Appeal Decision

Appeal Ref: APP/R4408/D/19/3221071

21 Kings Court, Wombwell, Barnsley, S73 0FB

- The appeal is made under section 78 of the Town and Country Planning Act 1990 against a refusal to grant planning permission.
 - The appeal is made by Mrs Lorna Akyel against the decision of Barnsley Metropolitan Borough Council.
 - The application Ref 2018/1374, dated 30 October 2018, was refused by notice dated 23 January 2019.
 - The development proposed is a brick outbuilding to the rear of the dwelling.
-

Revision :	
Scale :	1:50 @A3
Date :	Nov 18
Drawn by :	KL
Project :	Proposed Garden Room
Title :	Planning Drawing
Drg No :	GR/01
Rev :

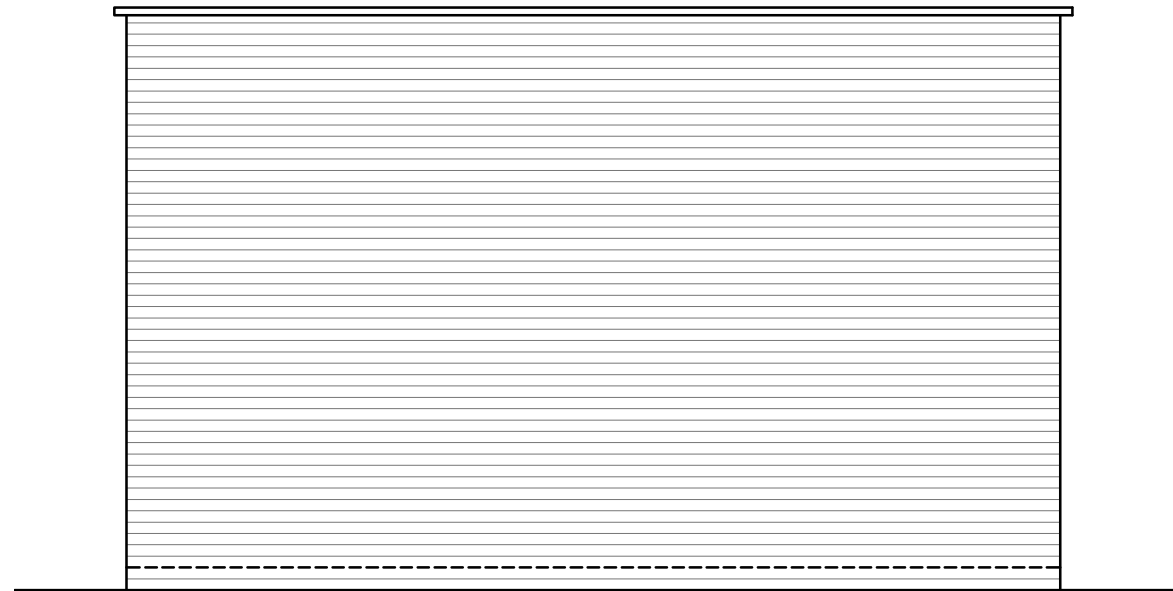
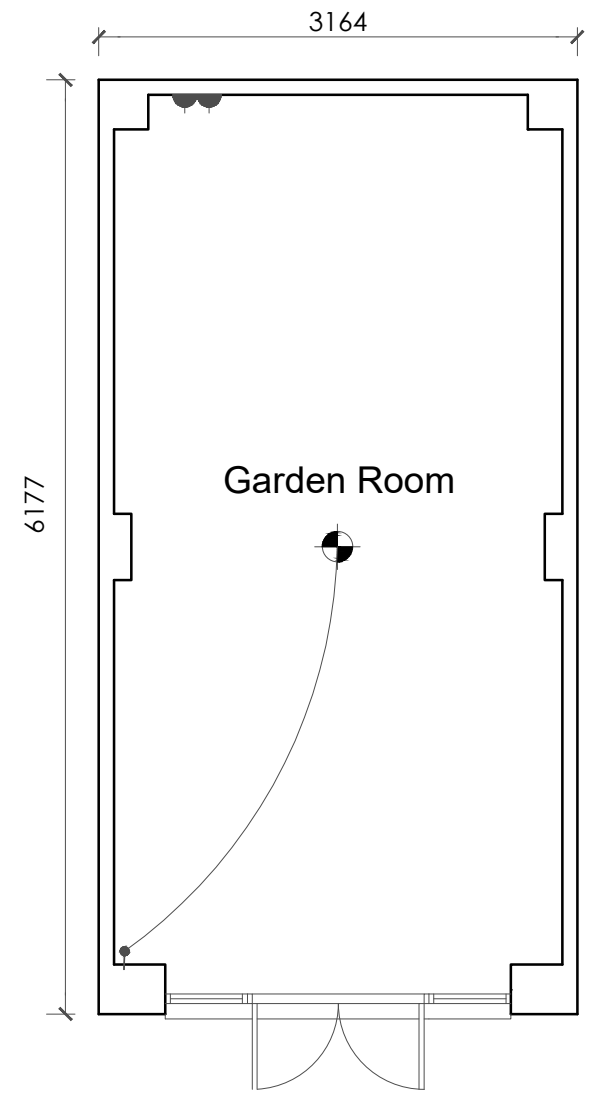
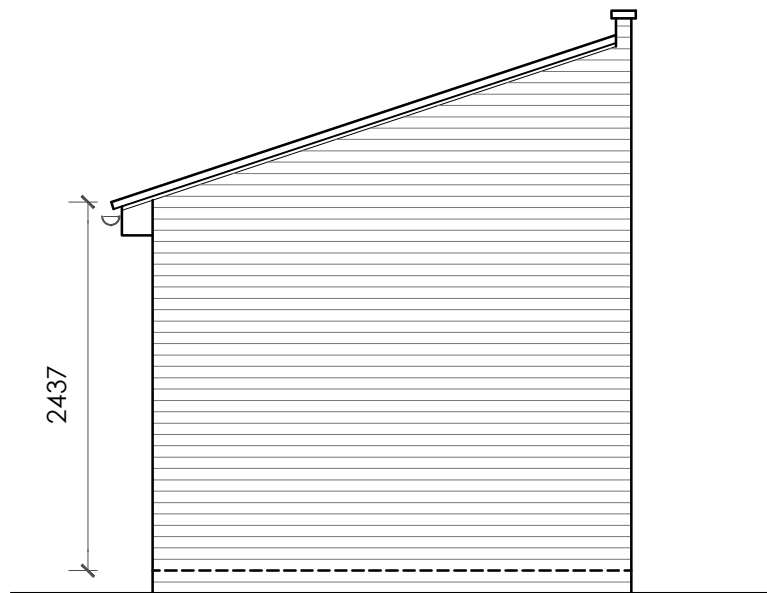
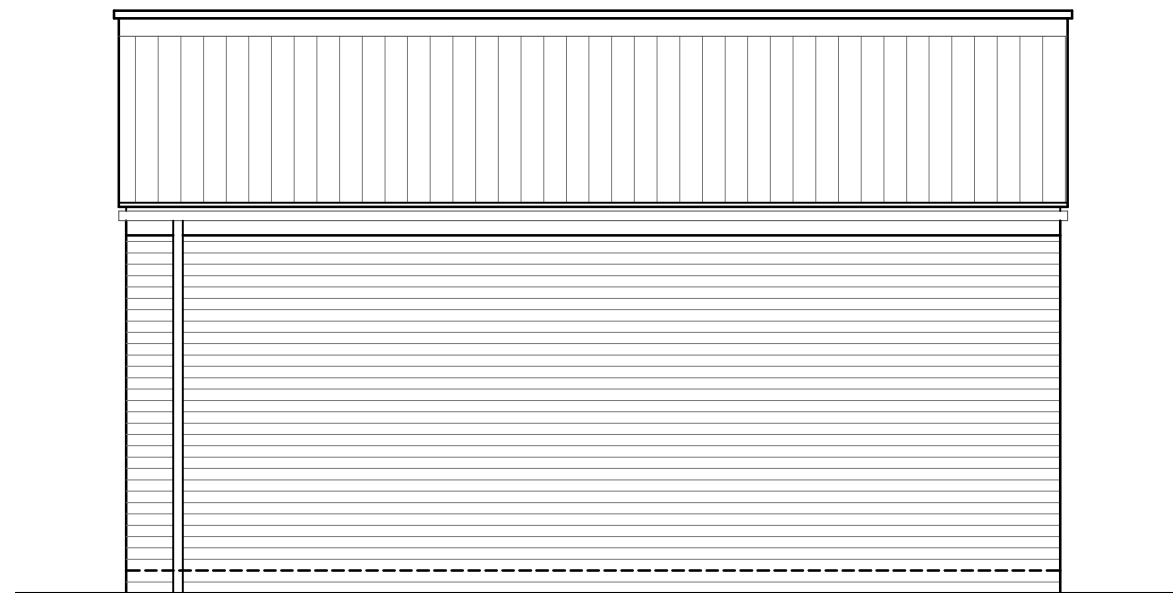
2. 21 Kings Court is a small detached dwelling with a pitched roof on a recently built residential estate. It is located in the top corner of a cul-de-sac. The brick outbuilding, which has already been constructed, is sited in the rear garden, alongside the side boundary. The original permission for the estate included a pair of garages at the front of the dwelling to serve the appeal dwelling and the neighbouring property but these were not built. The appellant says that the design of the building was based on what would have been their half of the approved garage block. As such, it has an unusual mono-pitched roof with the ridge alongside the side boundary.

3. It is sited on the rear part of the garden which is at a higher level than the ground floor level of the house and patio of the appeal property and is higher than those of the more traditional houses to the side. With a ridge height of 3.8m, it is significantly higher than the boundaries of the property. Consequently, despite being hidden from public view, it can be seen from many of the surrounding houses. Its siting, scale and height make it unduly prominent and although it has matching materials to the house it appears stark and incongruous, neither reflecting the roof form and pitch of the house or providing a low key solution as a flat roof may have done.
